CITY OF ALBUQUERQUE

PLANNING DEPARTMENT – Development Review Services

**RE: 101.7 The Team Radio
Drainage Report
Engineer's Stamp Date 7-03-2014 (File: C12D026)**

Based upon the information provided in your submittal received 7-03-14, the above referenced report cannot be approved for Site Plan for Building Permit or Building Permit until comments are addressed:

**Basin Map**

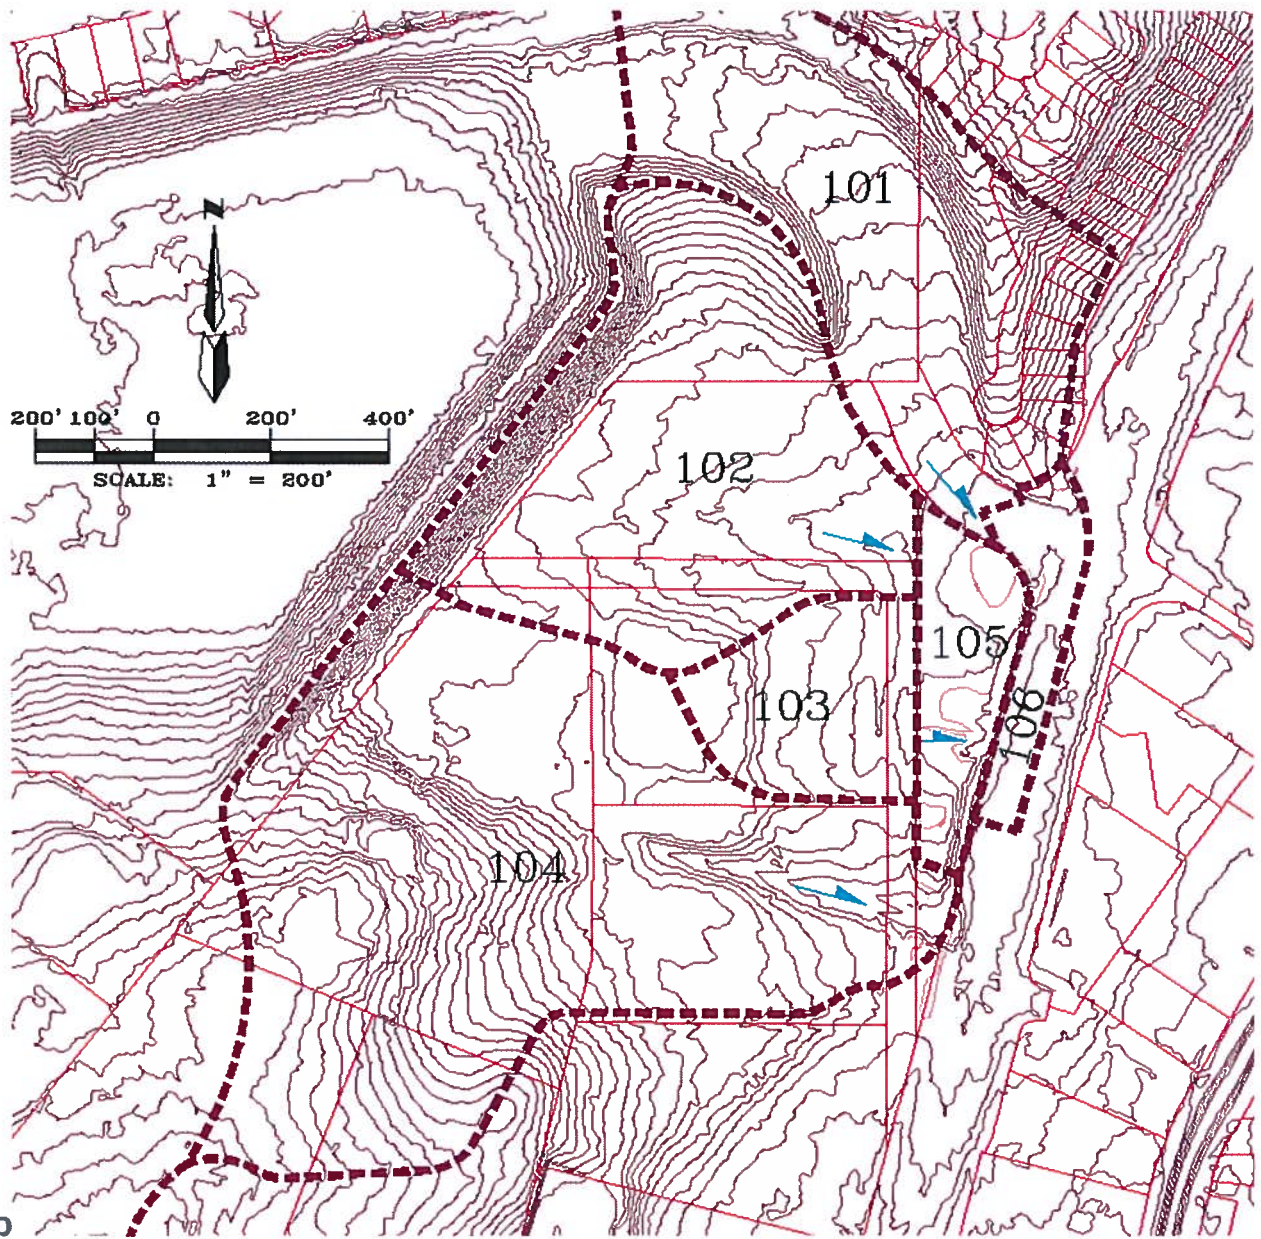
5. The Basin map shows contours of an undeveloped condition. The basin map should reflect the existing conditions which would support the land treatment shown. Additionally, any existing drainage paths (streets flow, inlets, Storm Drains) and the corresponding drainage outfall should be indicated in order to understand the bigger picture.
